Demolition of the existing garage building (B2 industrial use) and redevelopment of the site providing 9no C3 residential units - This application affects the character and appearance of River Road Conservation Area.

25 River Road Littlehampton

Thank you for your internet representation made on 20th June 2019 which has been recorded as '**an objection**' with the comments as follows:

LU/126/19/PL 25 River Road, Littlehampton

Drawn By
Terminus Place
North & South Elevations

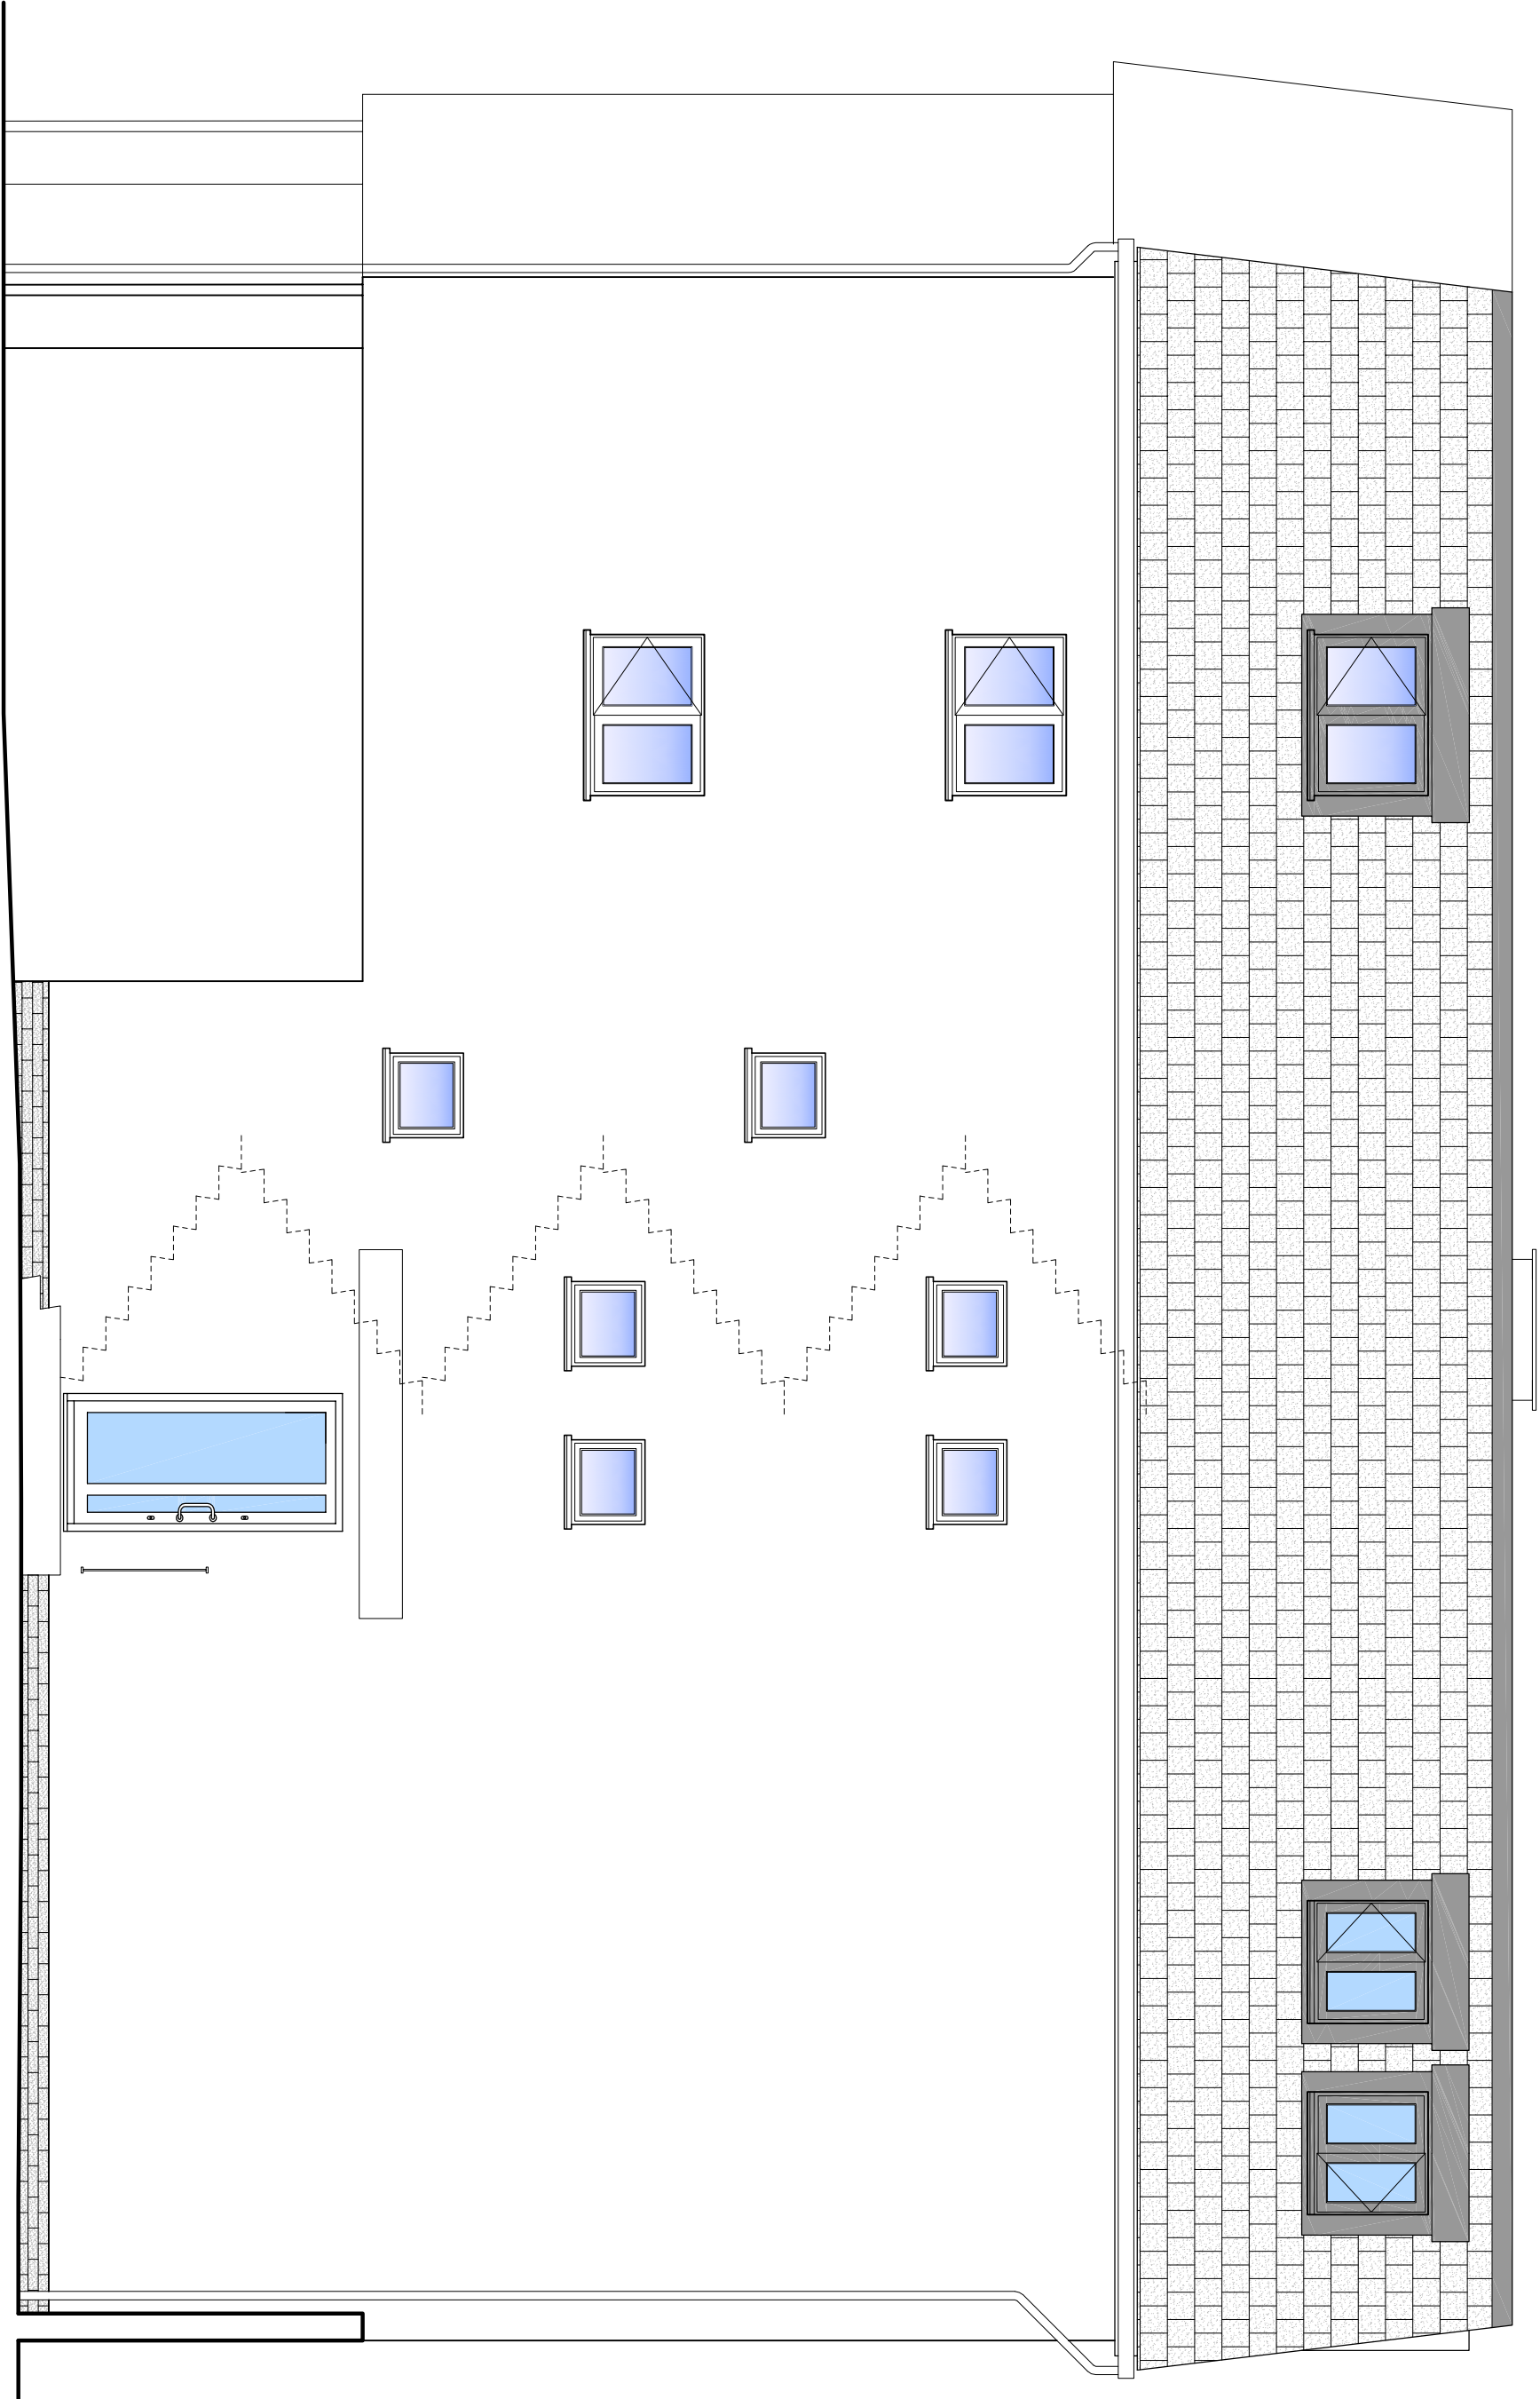
The proposed development is in the River Road Conservation Area and, as such, will have a harmful effect on it. It is overlarge, too high, too dense and far below the quality of form and design that should be expected for this site.

A Mansard roof is not appropriate in the Conservation Area where most of the properties are two storeys and have traditional roof shapes. The development should complement the houses on the eastern side of Terminus Place which is a terrace of two storey, small scale houses with traditional windows, doors and roofing. As proposed, the development would completely dominate and have a harmful effect on this terrace.
